Case Officer: Richard Greig

Applicant: Heyford Park Commercial Developments LTD

Proposal: Discharge of condition 5 (Landscaping Scheme) of 19/02337/F

**Soft Landscape Proposals  
Building 457, Heyford Park**

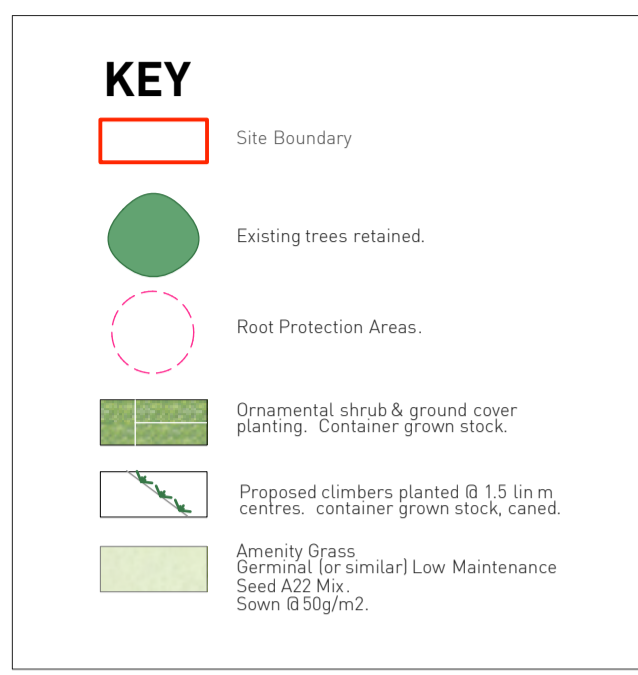
I think views across this space towards the green (Originally cricket field) the market square, etc are important for legibility, however there should be a feature tree at the 'treeless' pedestrian, diagonally aligned, entrances, each planted within the larger triangular section of the border. Each tree should be a Liquidambar styraciflua 'Worplesdon', 16 -18 cm. Tree pit details will be necessary.'
